MEMORANDUM

TO: Jean Fraser, Planner
FROM: David Senus, P.E.
DATE: July 6, 2015
RE: 1342 Congress Street Neighborhood Center, Final Level III Site Plan Application

Woodard & Curran has reviewed the response to comments and Final Level III Site Plan Application submittal for the for the proposed Neighborhood Center at 1342 Congress Street. The project involves the construction of a 19,300 SF building with associated site improvements that include a surface parking lot, stormwater management system, utilities, site lighting, and landscaping. The project will disturb approximately 85,000 SF and result in 12,500 SF of additional impervious area.

INLET STRUCTURE DETAIL - PDMH#1
NOT TO SCALE

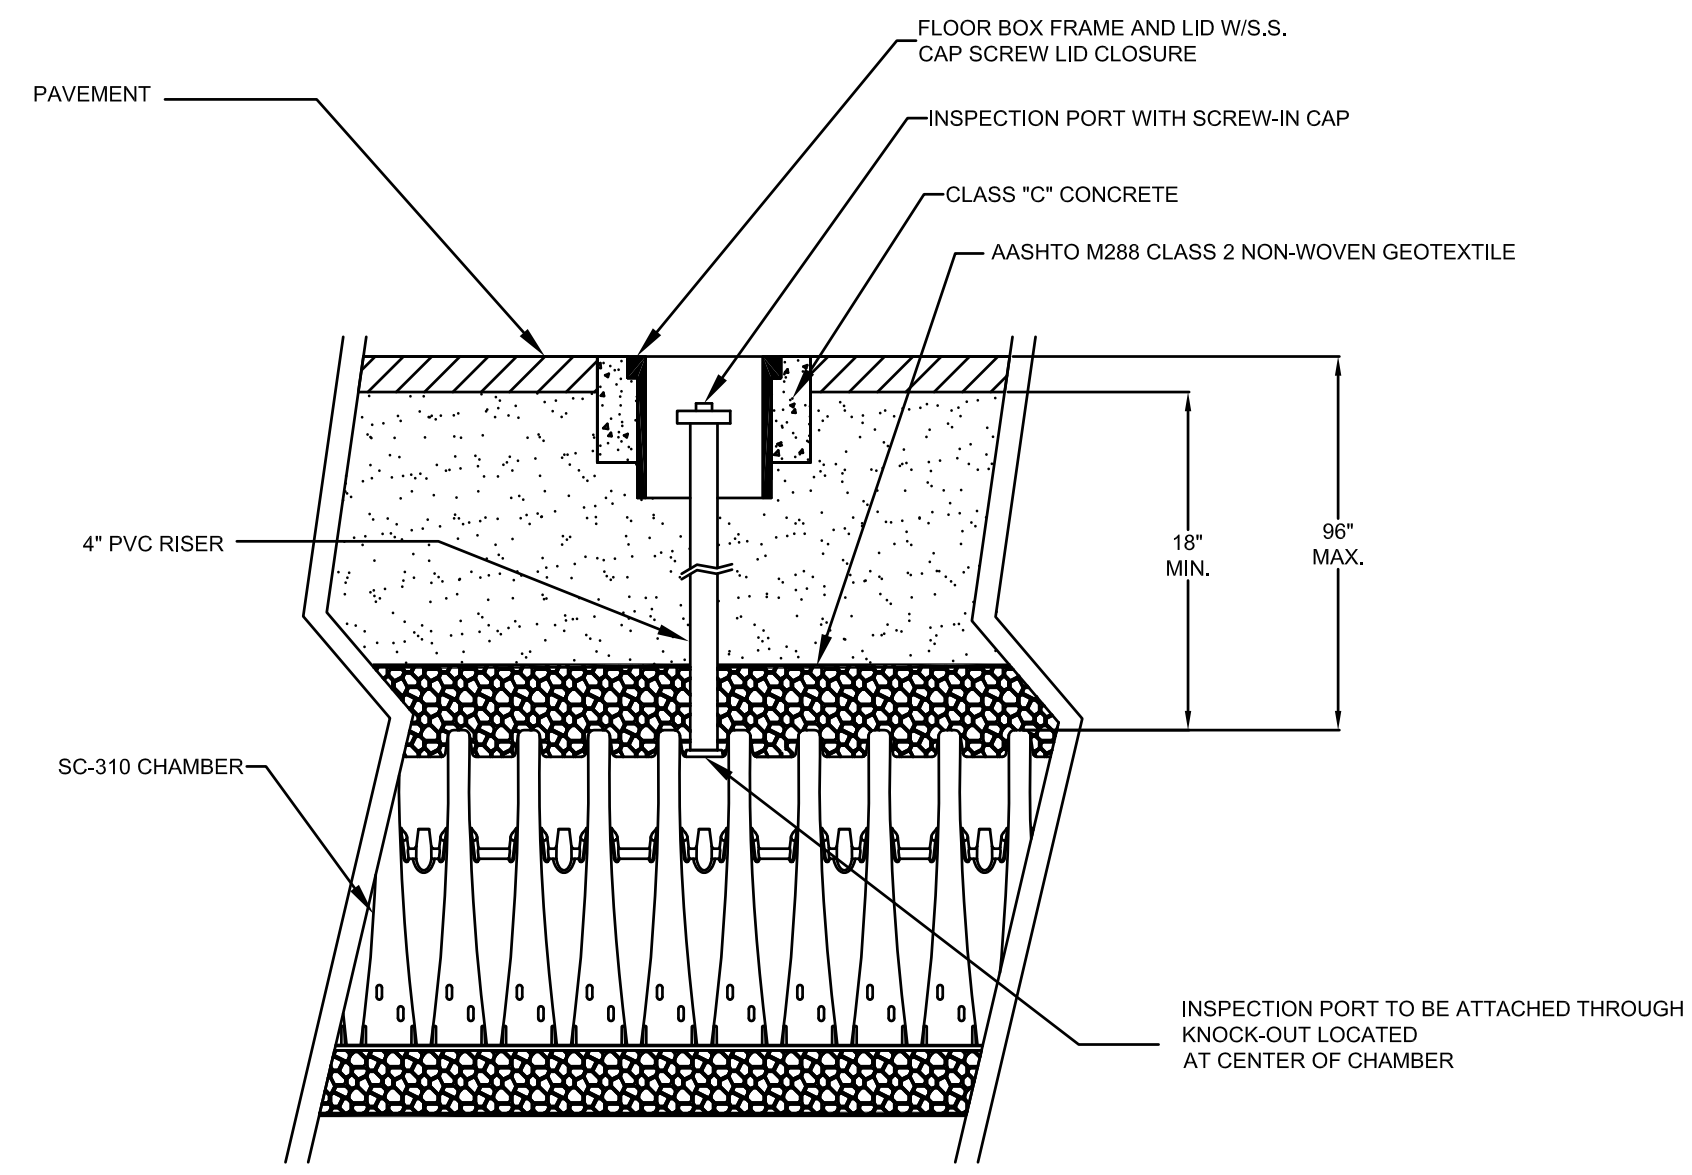
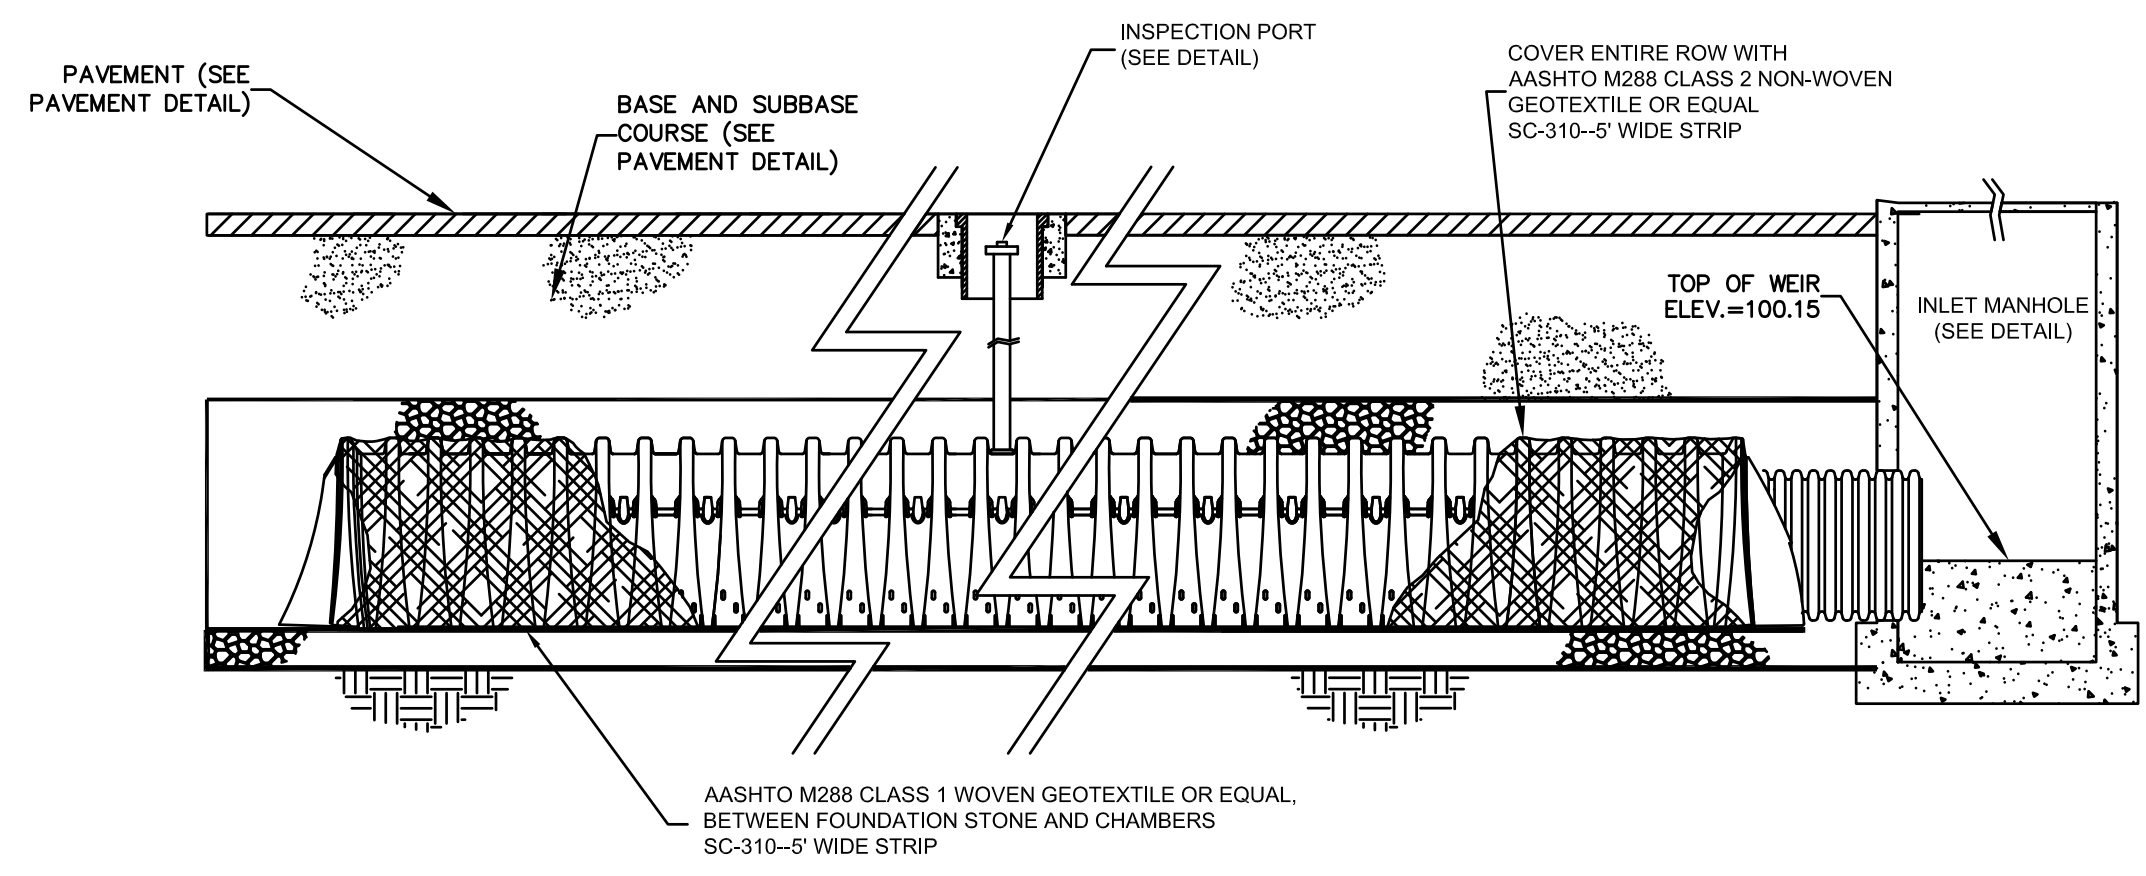
- ii) Future submittals should include details for the outlet control structures associated with the soil filter and the StormTech Chamber system, including orifices and weirs.

- iii) Future submittals should identify key elevations for the StormTech Chamber detail matching to the elevations utilized in the HydroCAD model.
 - iv) The Pre-Development Watershed Plan (WS-1) indicates that runoff from the existing building roof is part of catchments WS-1 and WS-2; however, runoff from some of these roof areas is collected in downspouts that enter into the ground and which do not appear to flow to PA-1 and PA-2. The Applicant should determine the discharge location for the building's roof downspouts and re-evaluate the catchment areas and stormwater model based on their findings.

-  CANOPY TREE
-  ORNAMENTAL TREE
-  EVERGREEN TREE
-  TURF
-  SHRUBS / ORNAMENTAL GRASSES / GROUNDCOVER
-  RAIN GARDEN PLANTINGS

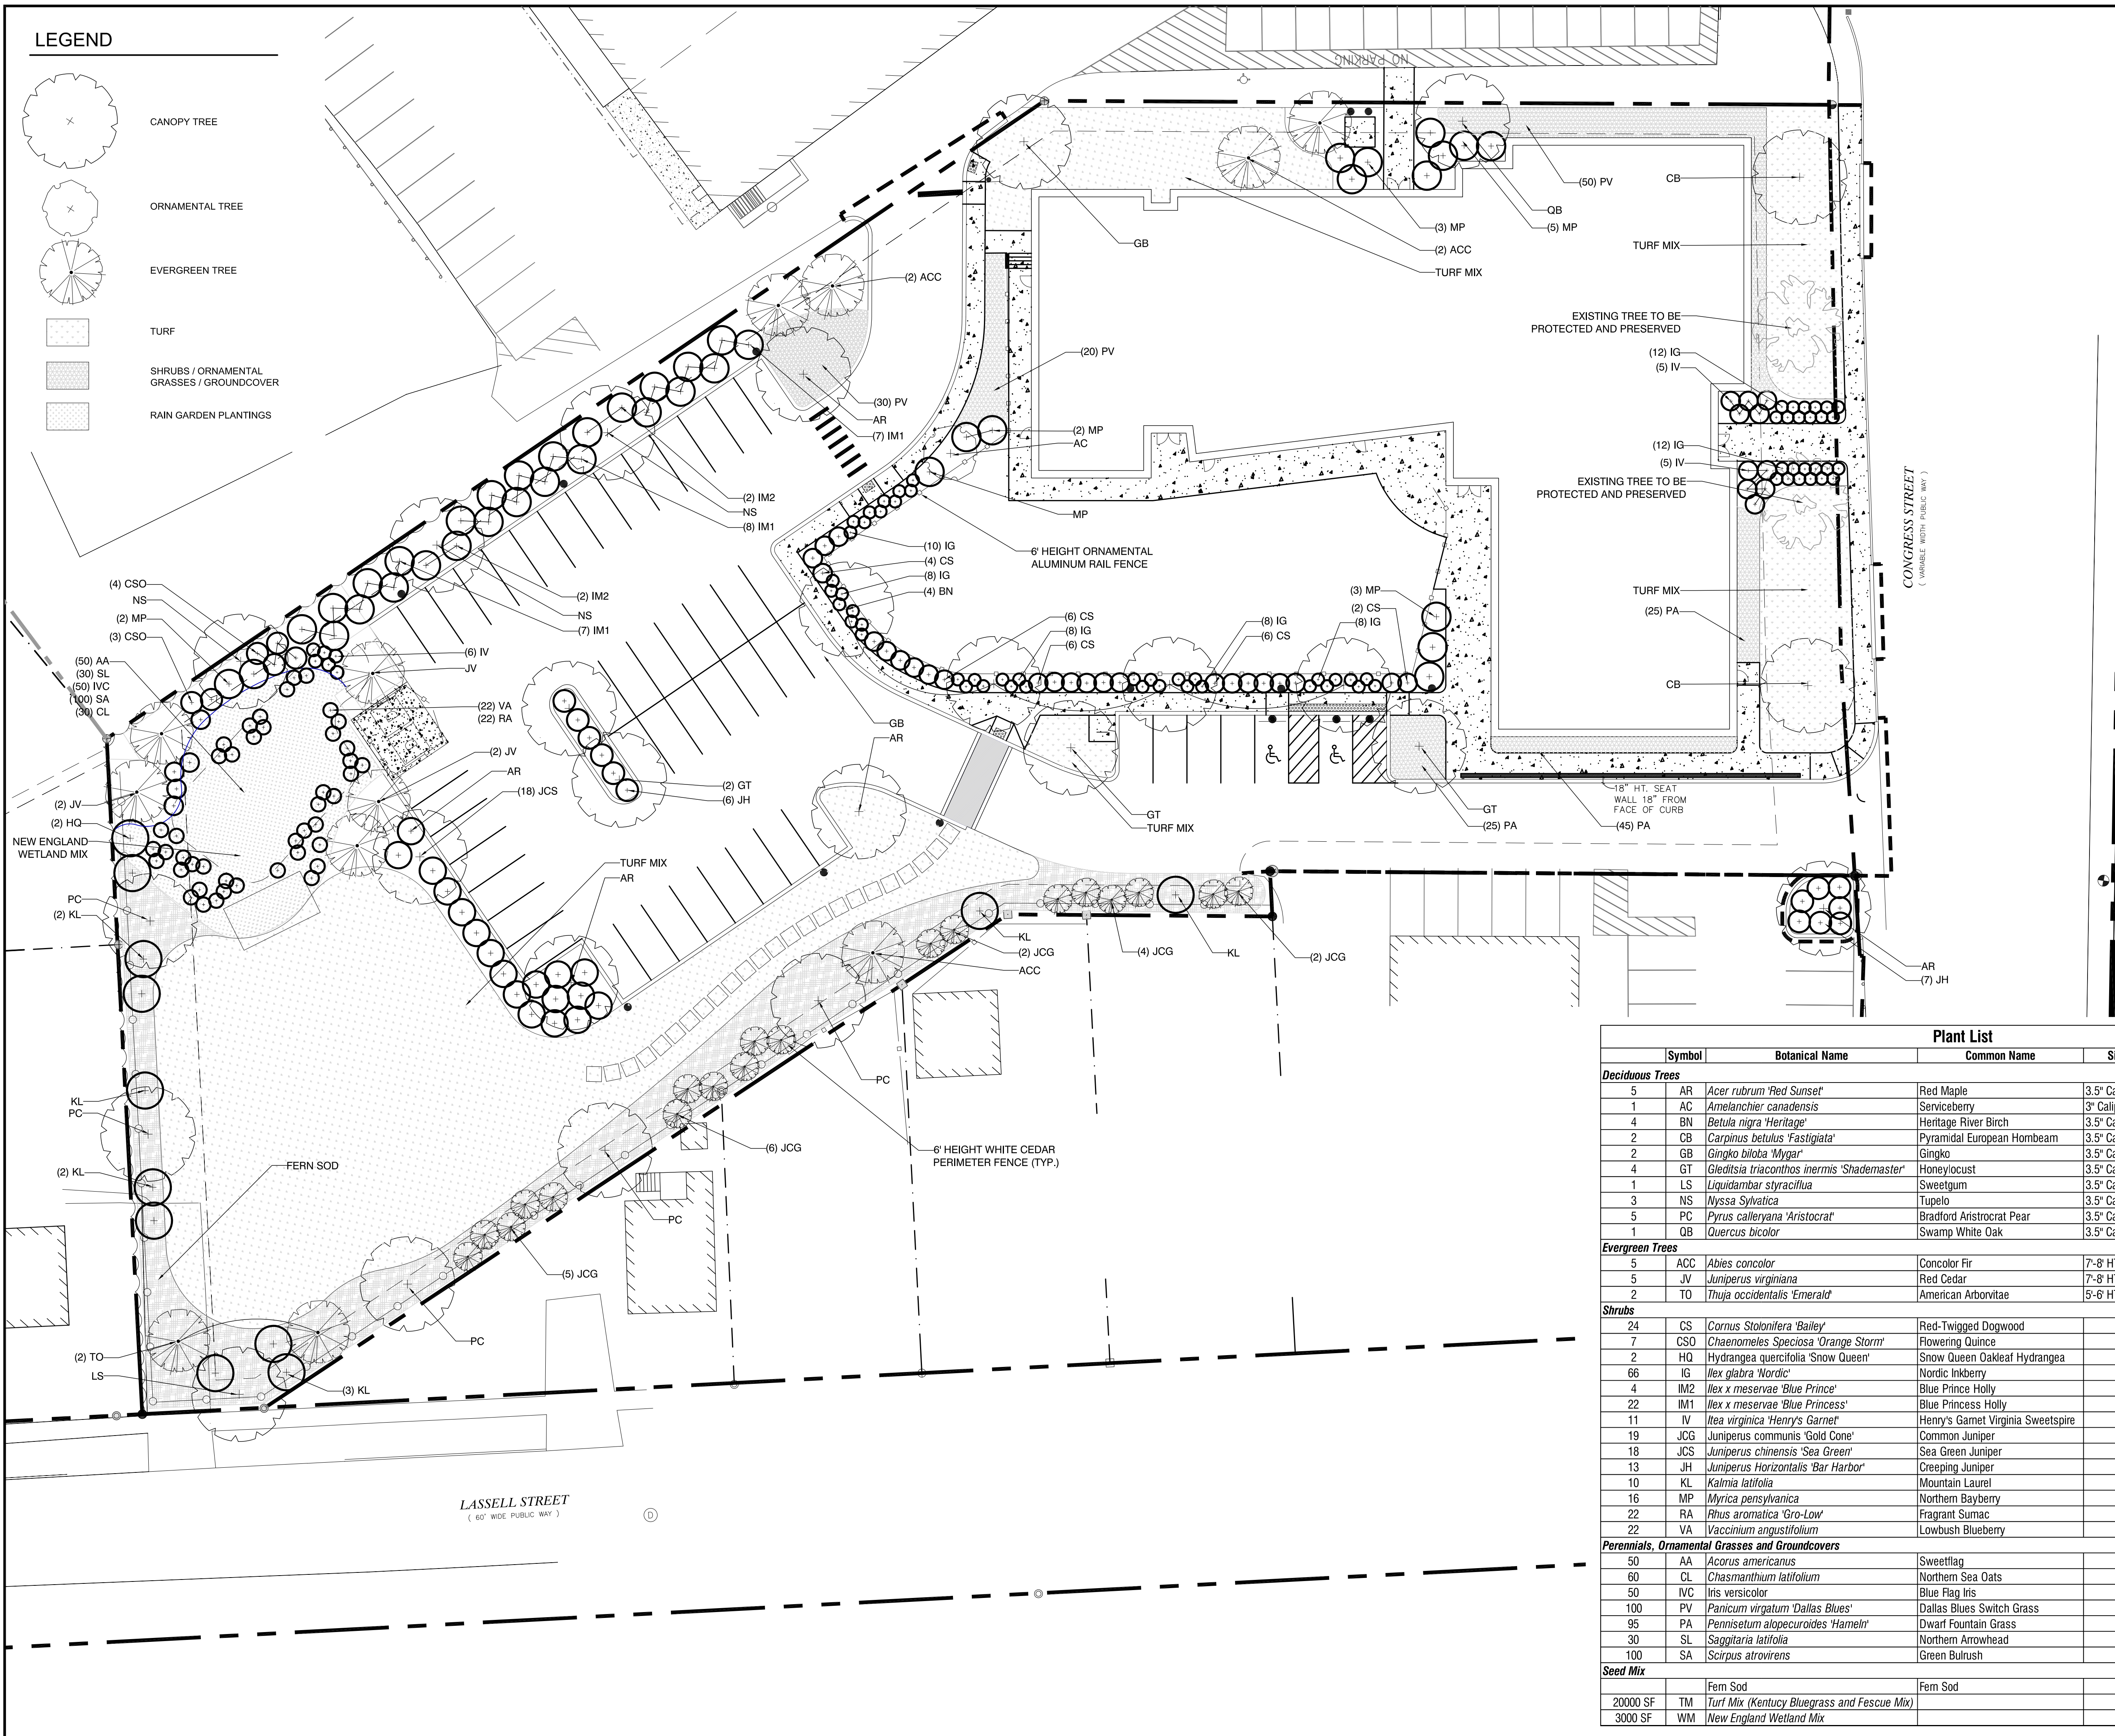
- 6) The proposed Underdrained Soil Filter Bed detail refers to a Rain Garden Planting Plan for proposed plantings; however, it does not appear that this plan has been provided at this time.
